**Application for a non-material amendment following a grant of planning permission,
Town and Country Planning Act 1990**

**Non material amendment to previous permission 2021/92708 for erection of
detached garden room**

70, Bywell Road, Dewsbury, WF12 7LH

Application Number: 2024/92352

Revisions		Planning Application for:	
Date	Aug 2024	Rear Garden Room 70 Bywell Road, Dewsbury	
		Drawing Title: Plans and Elevations	
		Drawing No:	Rev
		S01	E
		Scale: As shown	Paper Size: A1

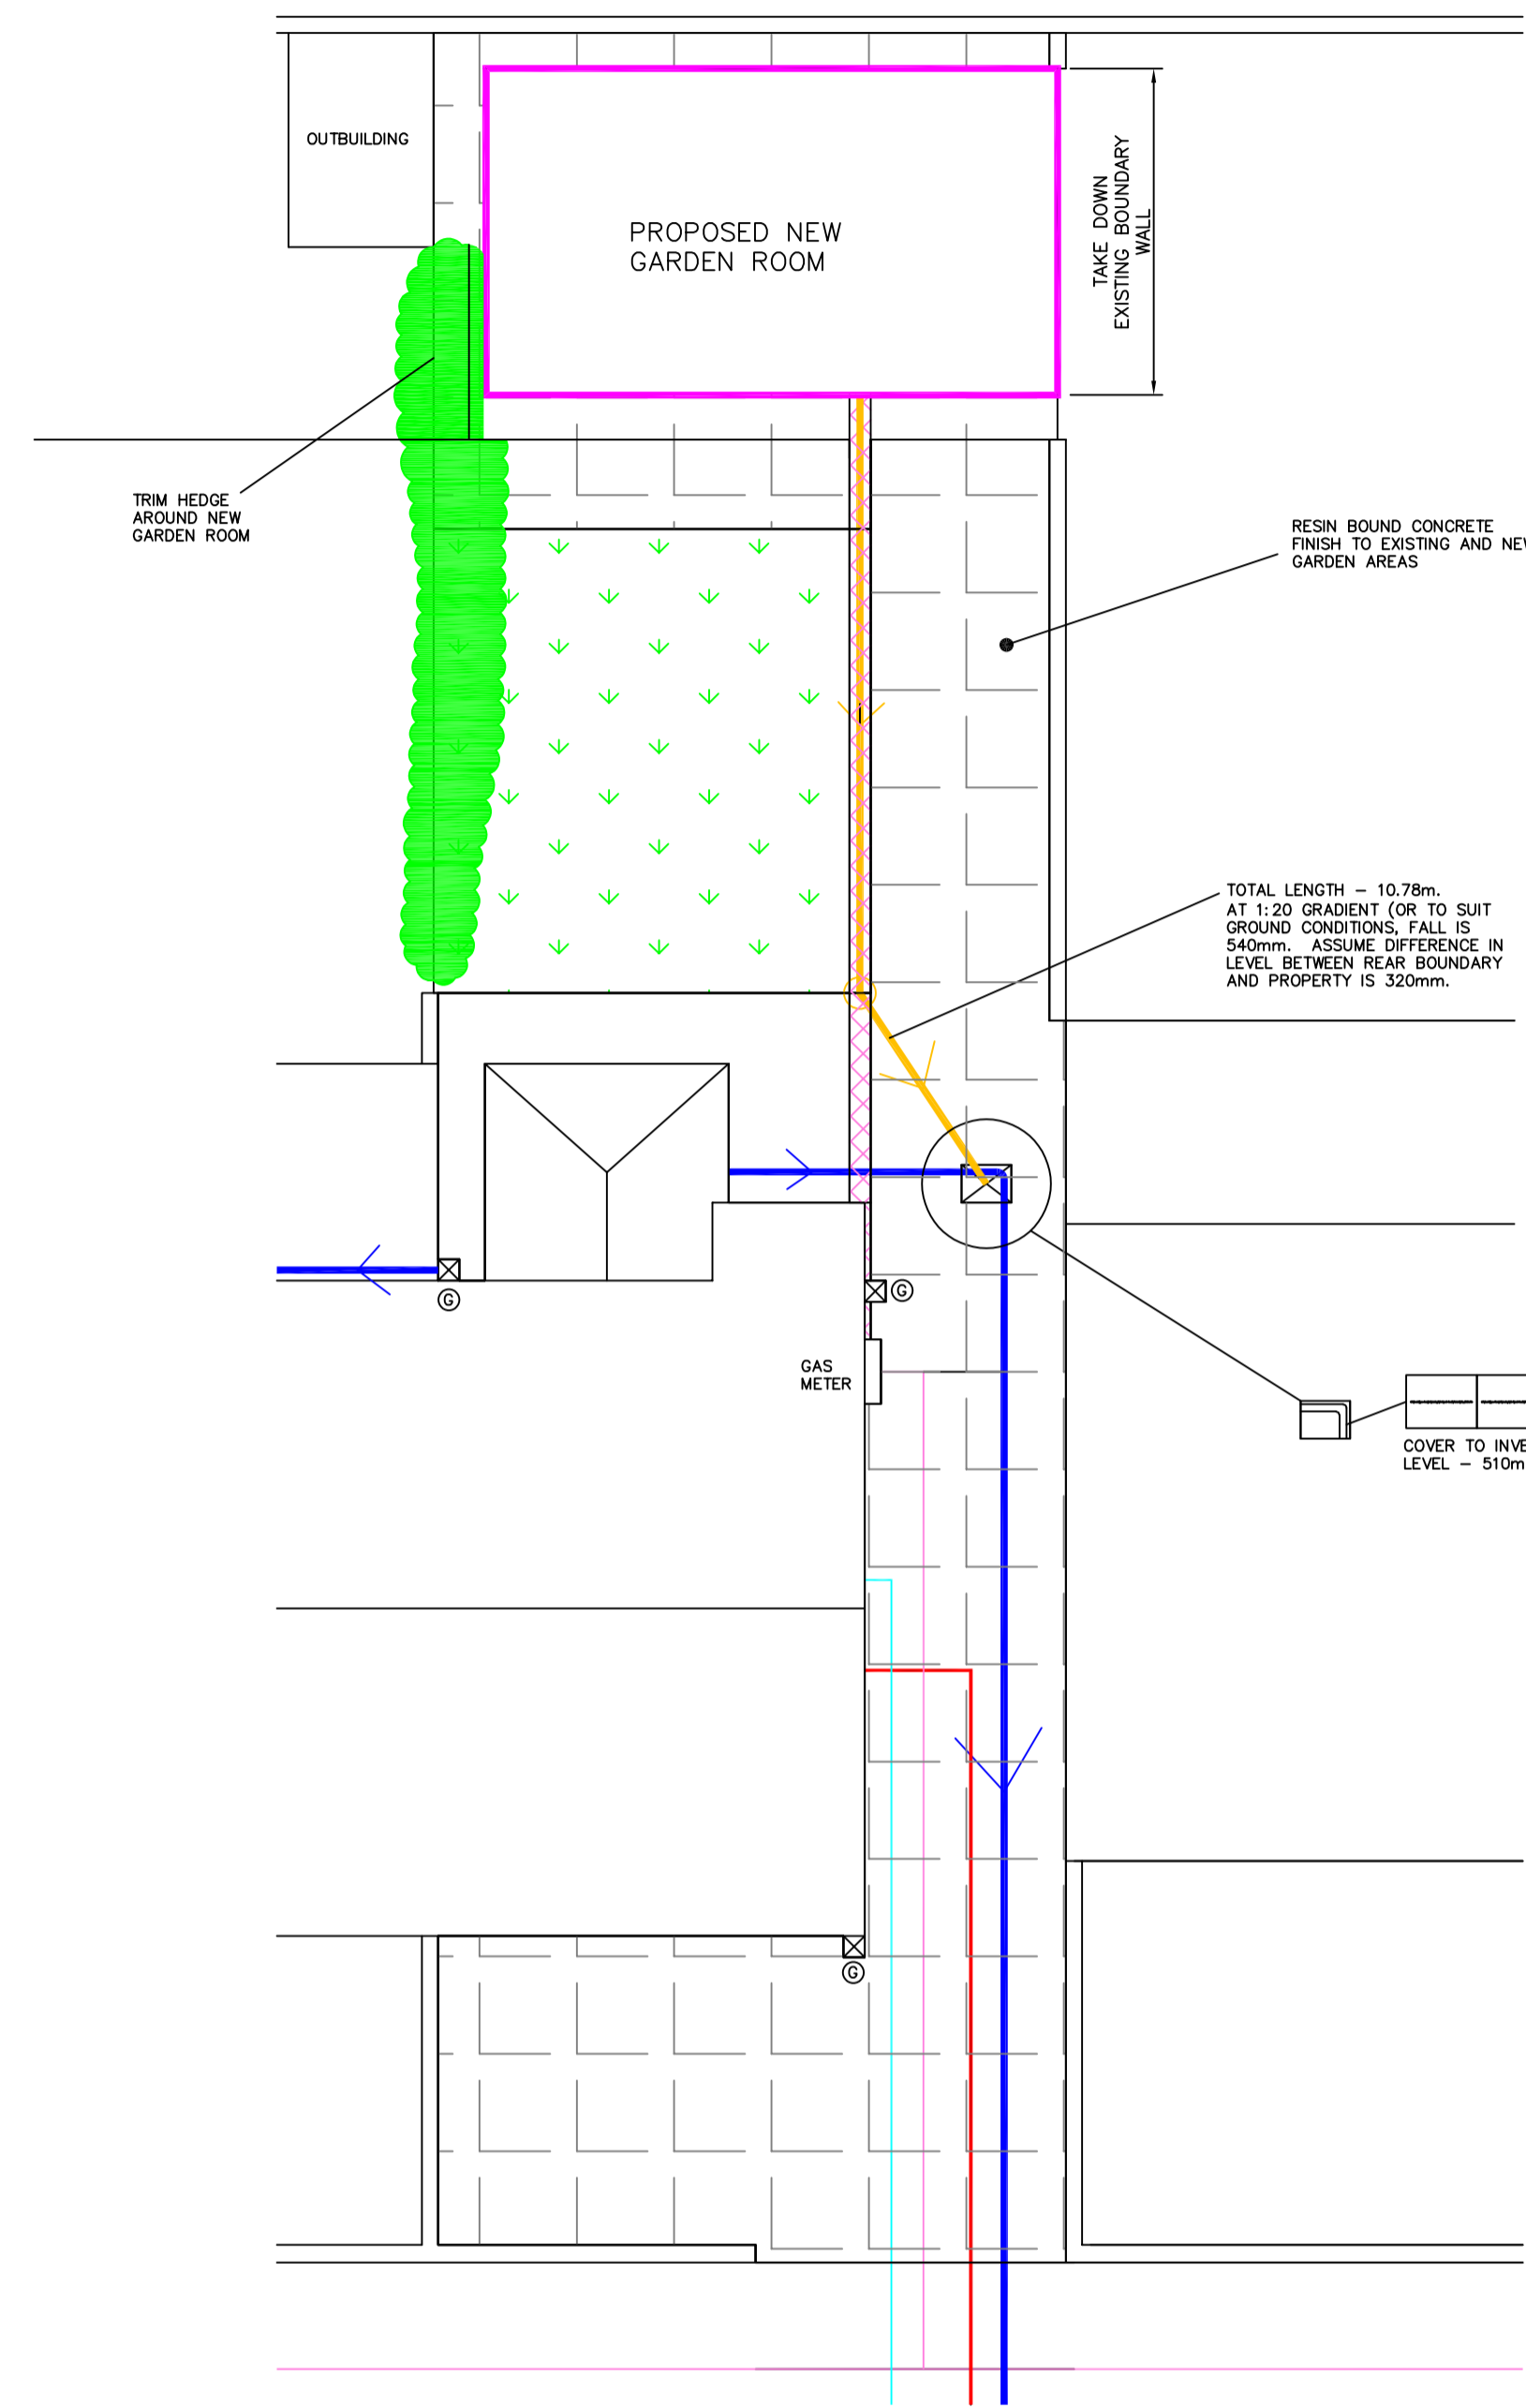
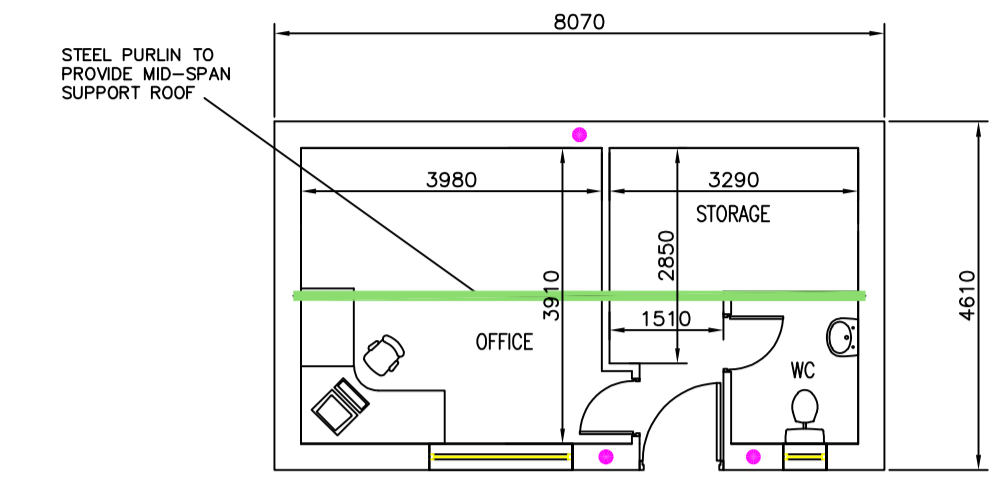
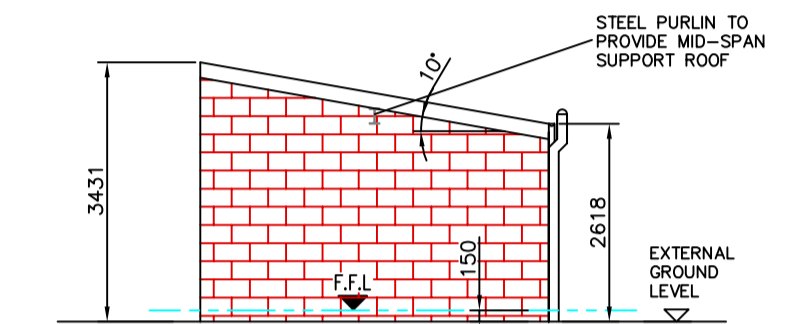
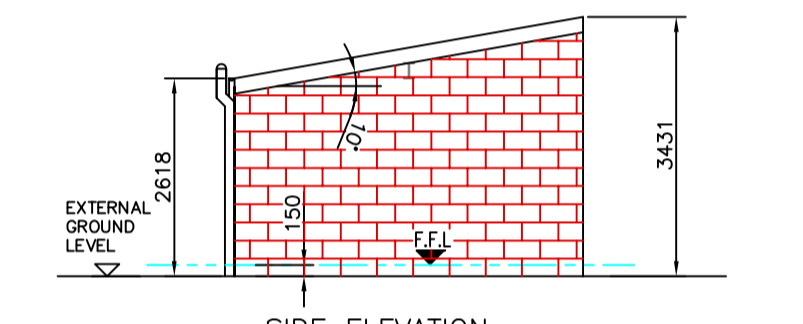
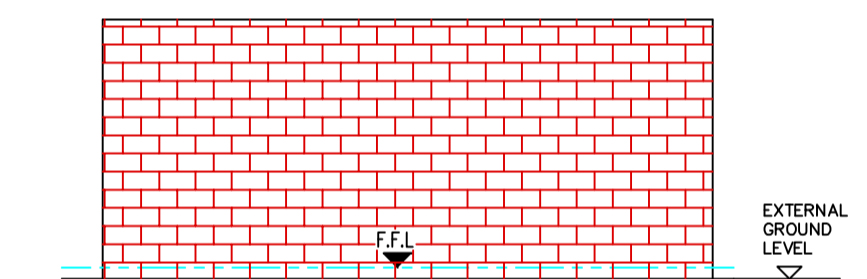
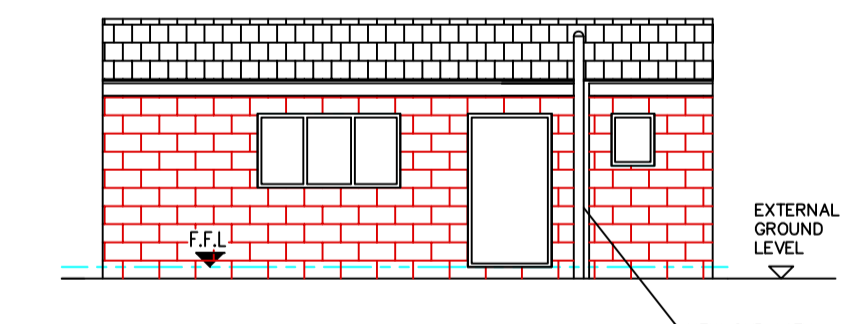
Thank you for your application dated 20-Aug-2024 for a non-material amendment to the above scheme. The amendment sought is to reduce the depth of the building from 5.2m to 4.6m, reduce the width from 8.3m to 8.1m and the height of the lower front height from 2.9m to 2.62m. The angle of the slope would increase. The amendments are shown on plans S01E submitted 20/08/2024.

I confirm that the alterations are acceptable and may be considered as a non-material amendment to the approved drawings. It should be noted that this letter relates only to the non-material amendment sought and it is not a re-issue of the original planning permission. The two documents should be read together and as such, all conditions imposed on the original granting of planning permission apply to the proposal as now amended. A copy of this letter and the amended plans will be retained on the public record of approved documents.
